**Application Reference:** 6/2020/3222/NMA

**Proposed development at:** Former Volkswagen Van Centre Comet Way Hatfield  
AL10 9TF

**Proposal:** Non-Material Amendment following planning permission for *“Demolition of existing buildings and construction of new building comprising 118 residential apartments, layout of parking areas, landscaping, electricity substation and ancillary development”* (6/2020/3222/MAJ)

While some proposed changes would be non-material, others represent material changes to the planning permission. Consequently, this application for a NMA is **refused**.

Drawing Number
HAT-RDB-XX-04-DR-A-NMA-0204

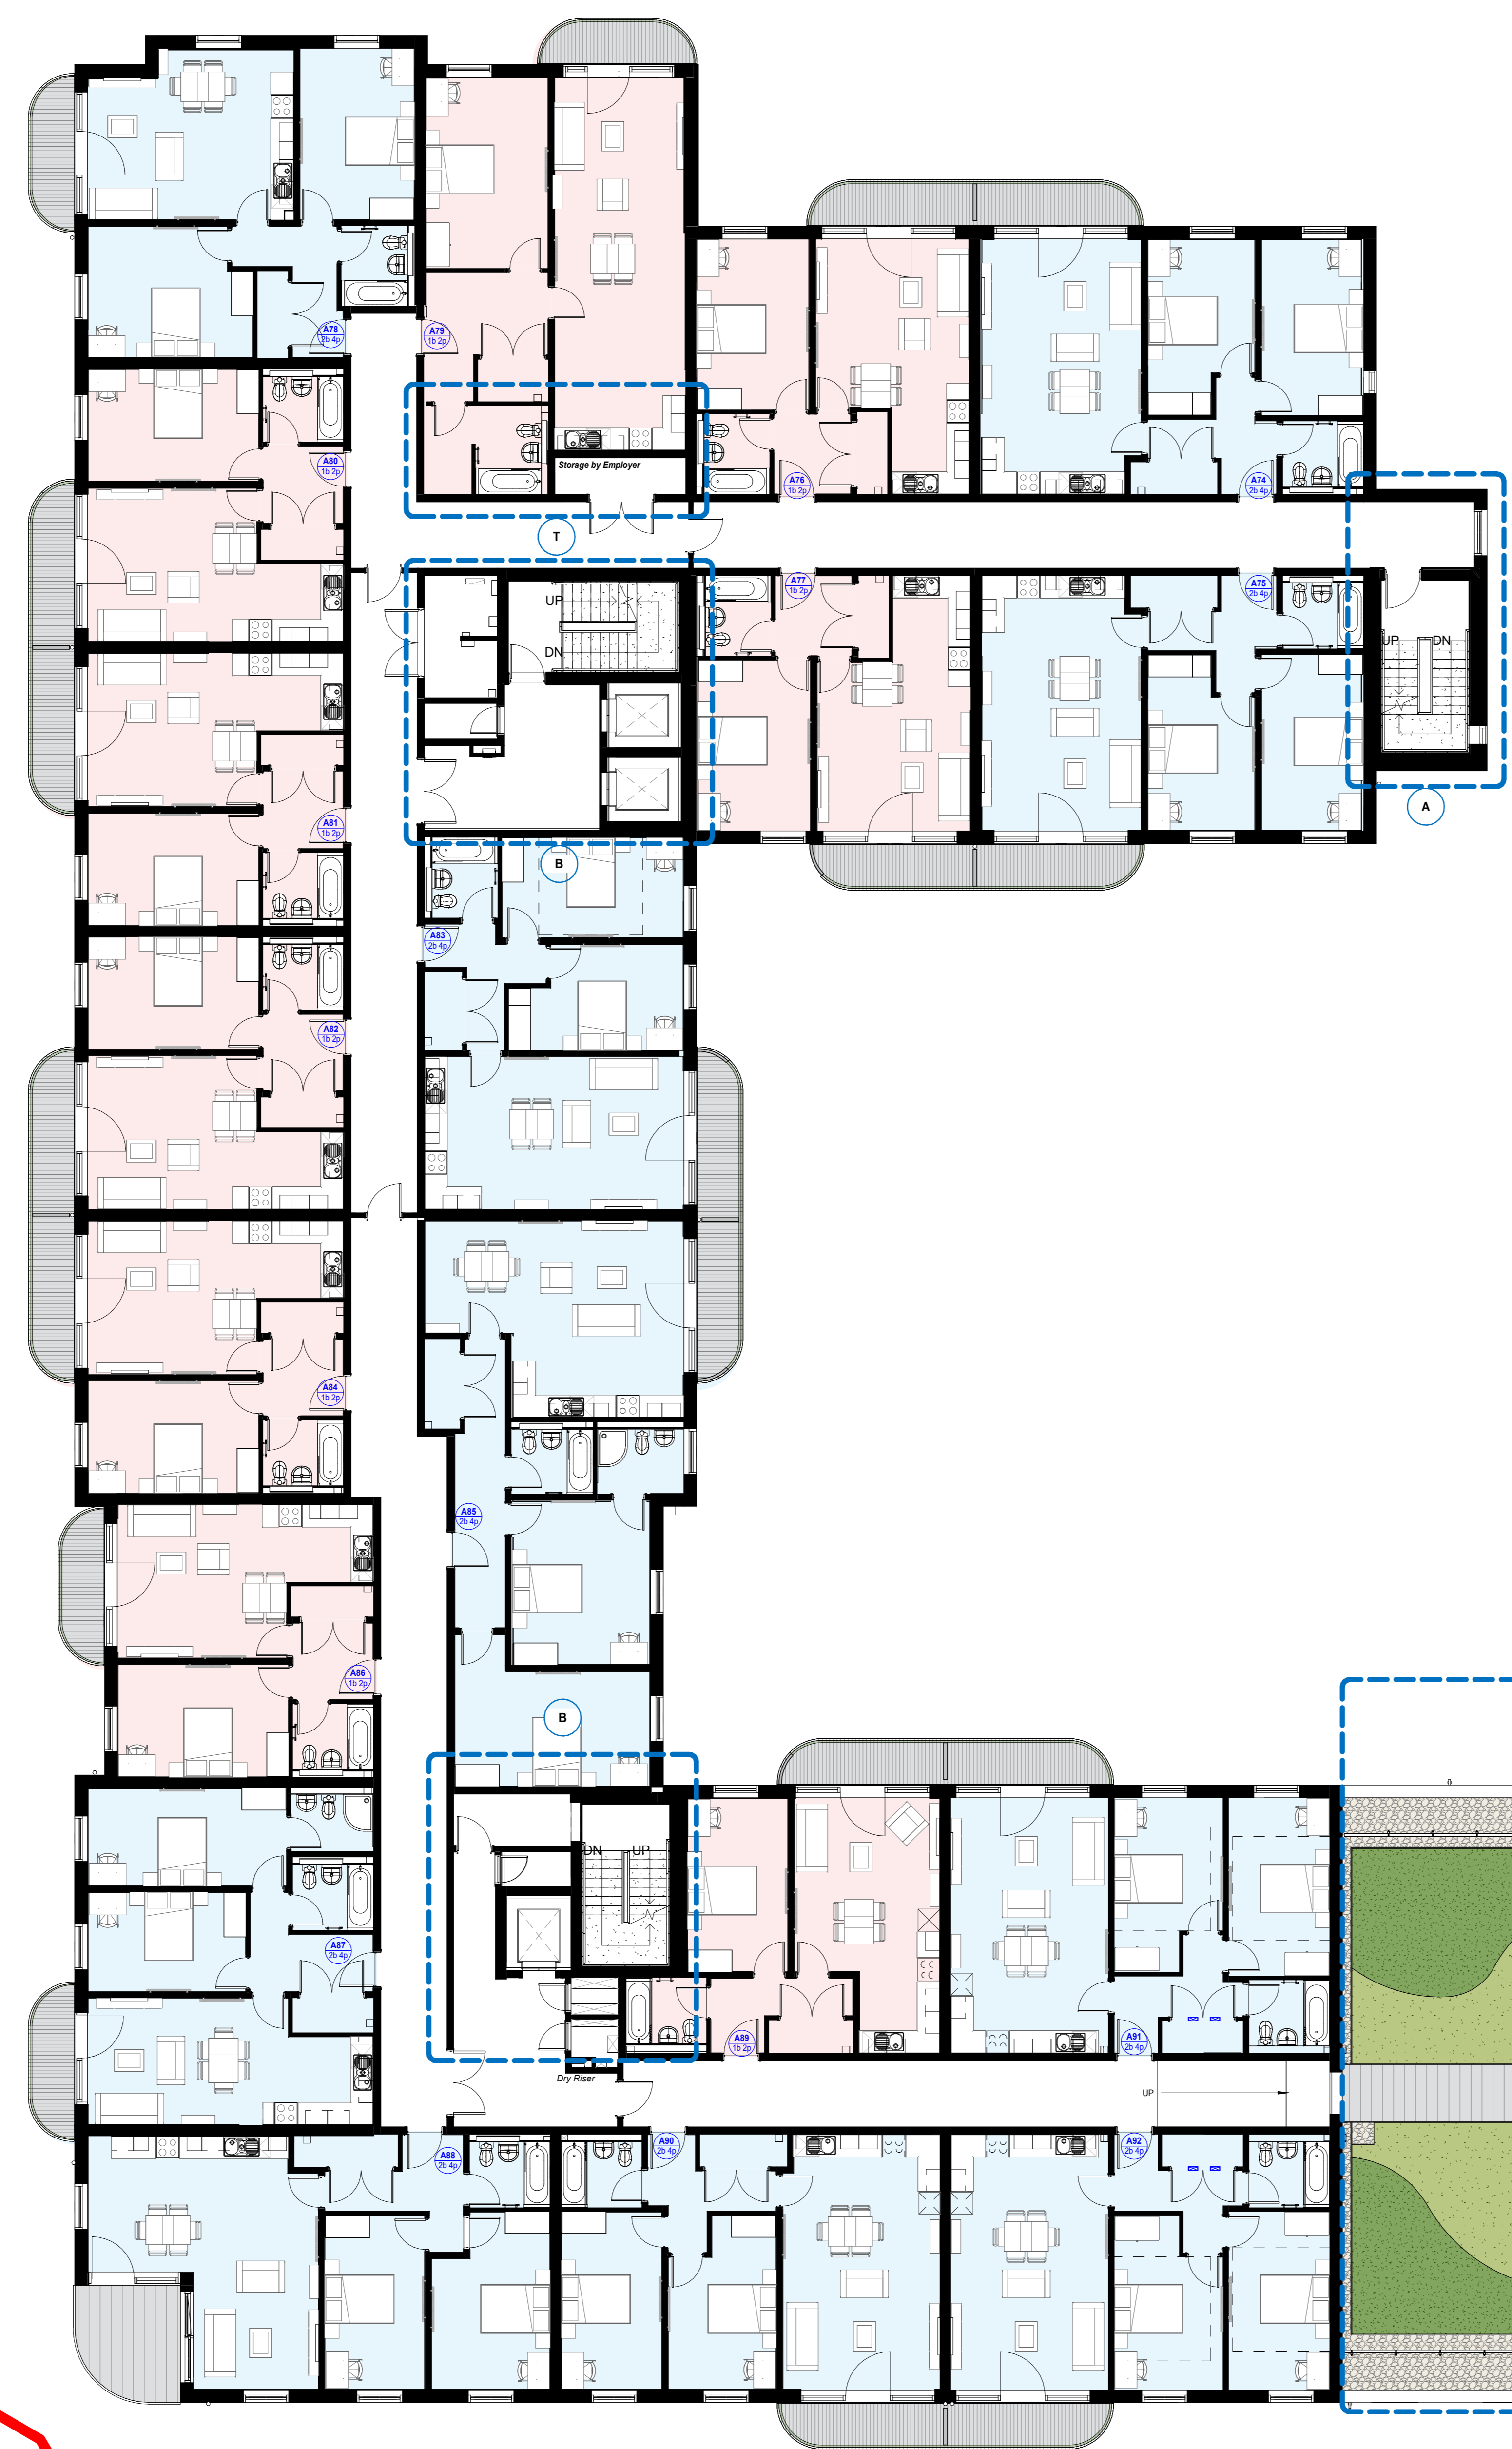
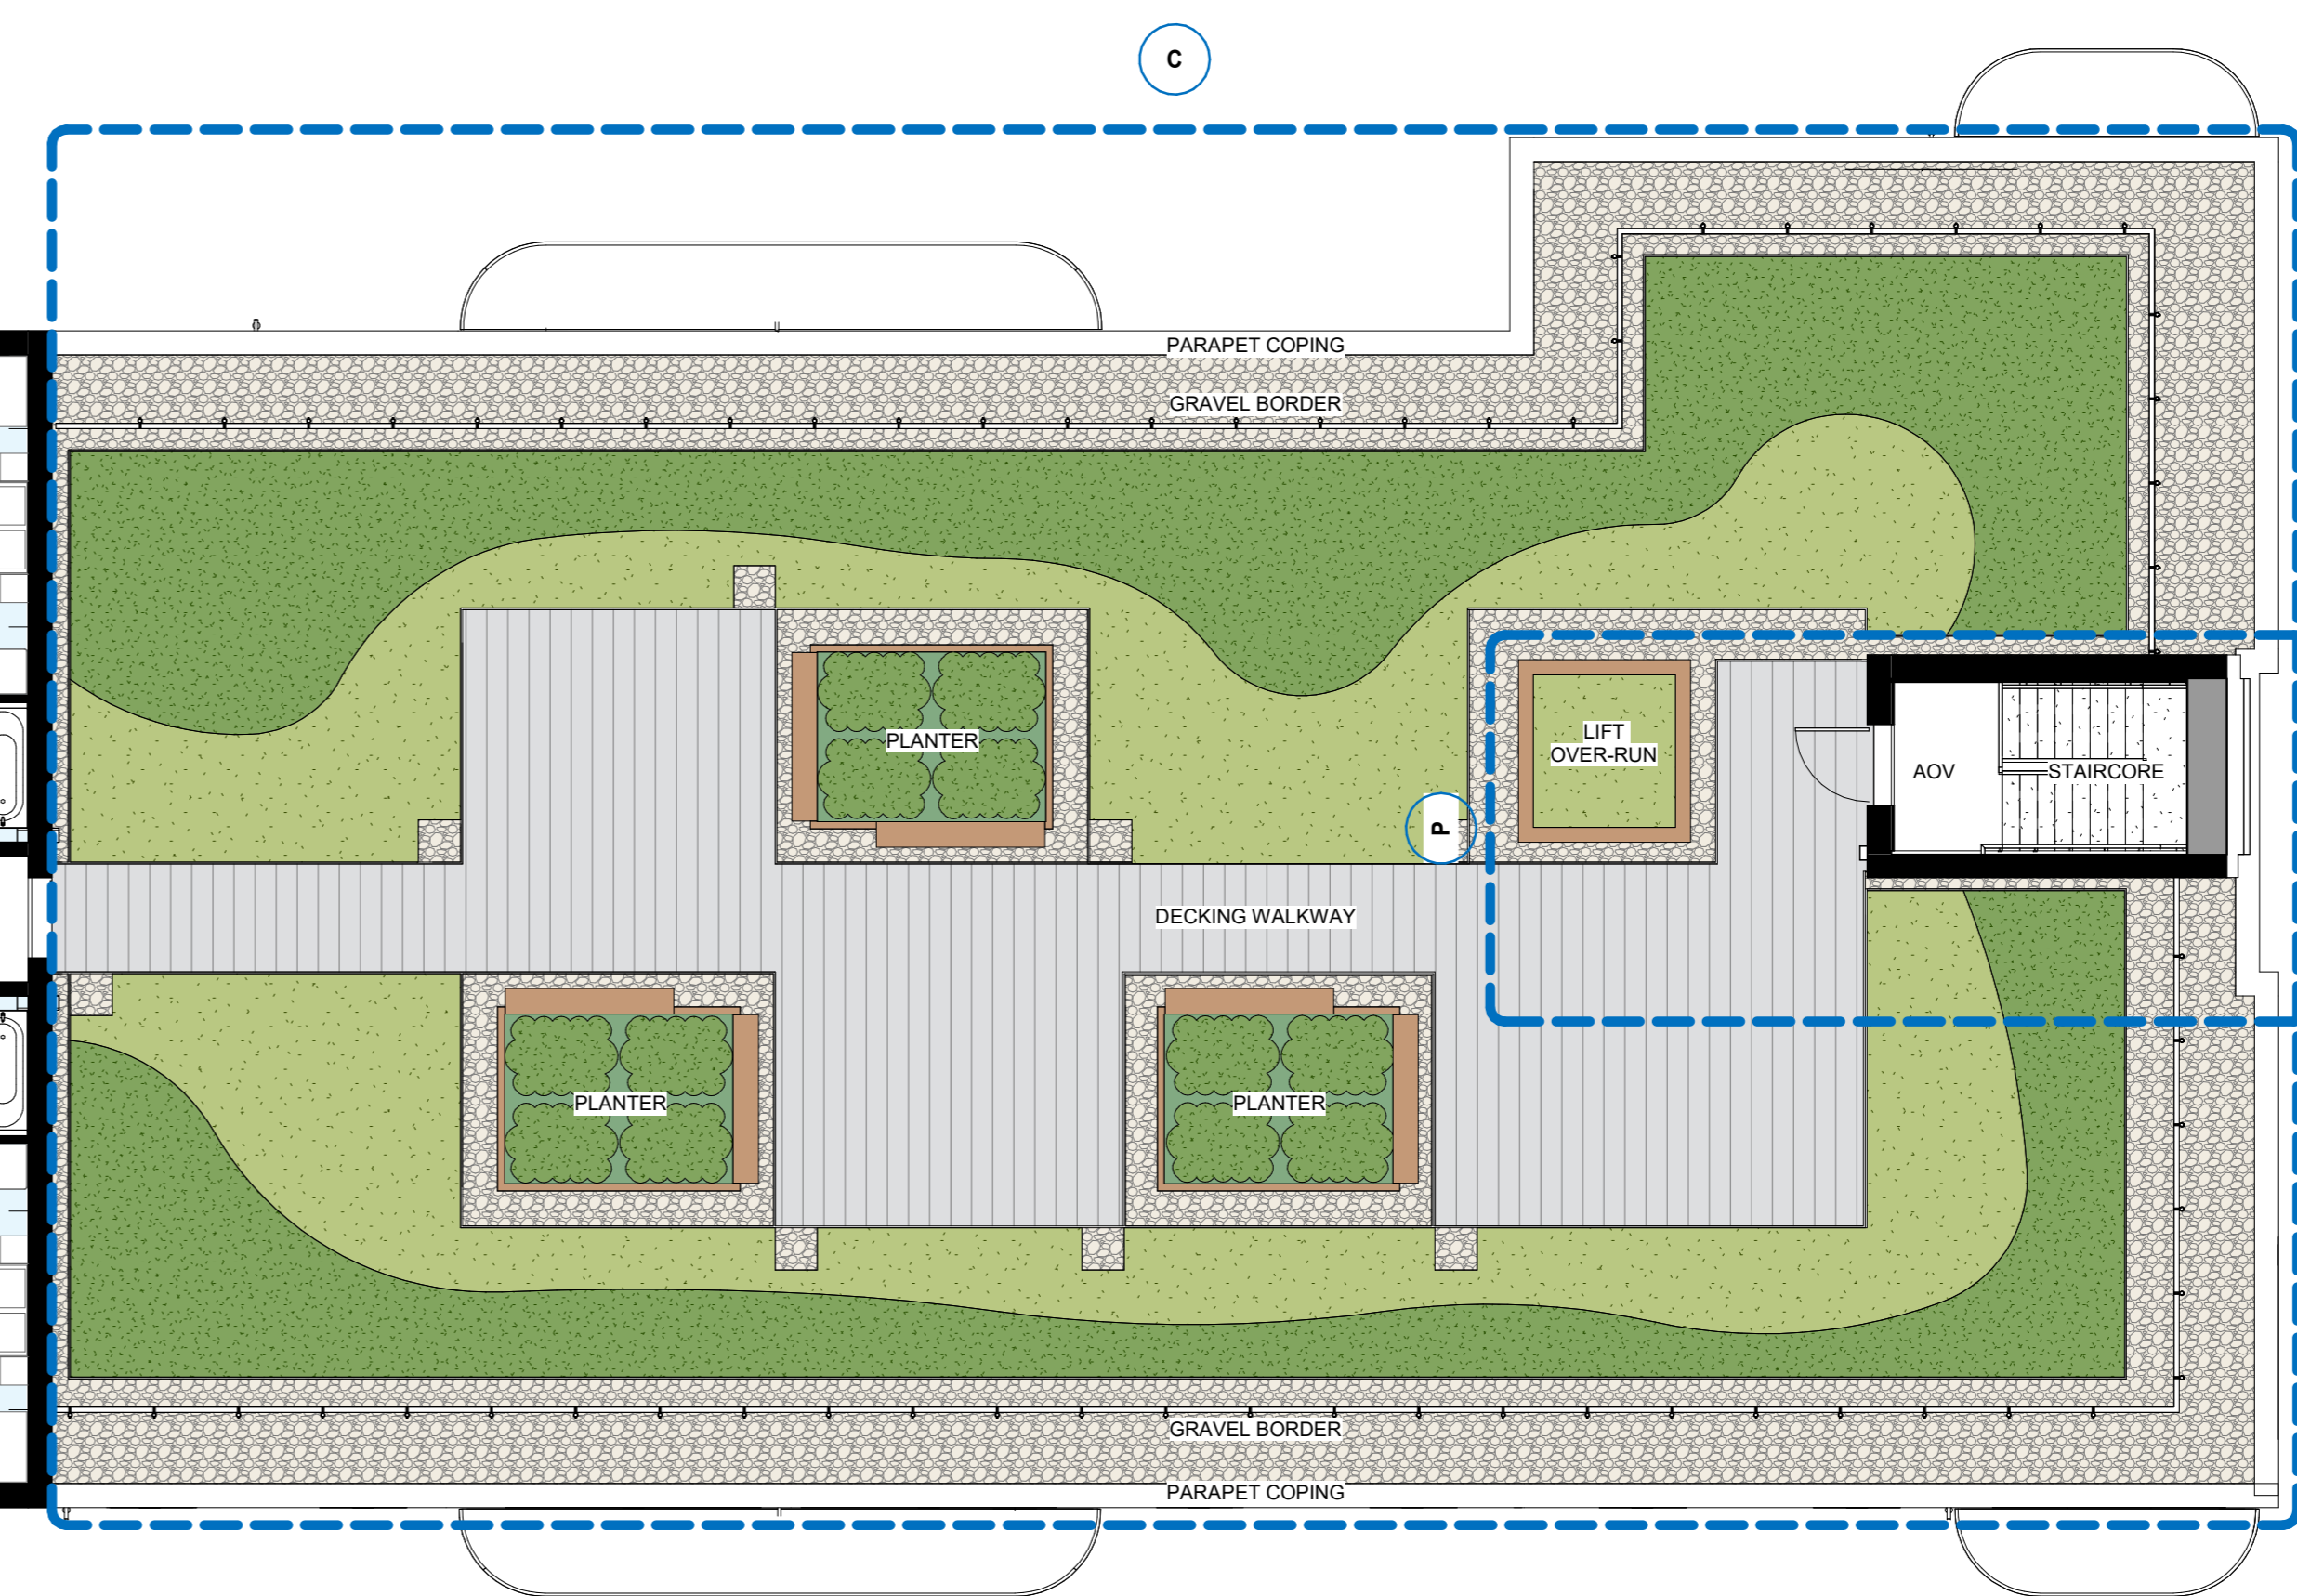
The Amended Fourth Floor Landscape Plan (drawing no: HAT-RDB-XX-04-DR-A-LND-0204) and Amended Fifth Floor Landscape Plan (drawing no: HAT-RDB-XX-05-DR-A-LND-0205) are acceptable and considered to be non-material.
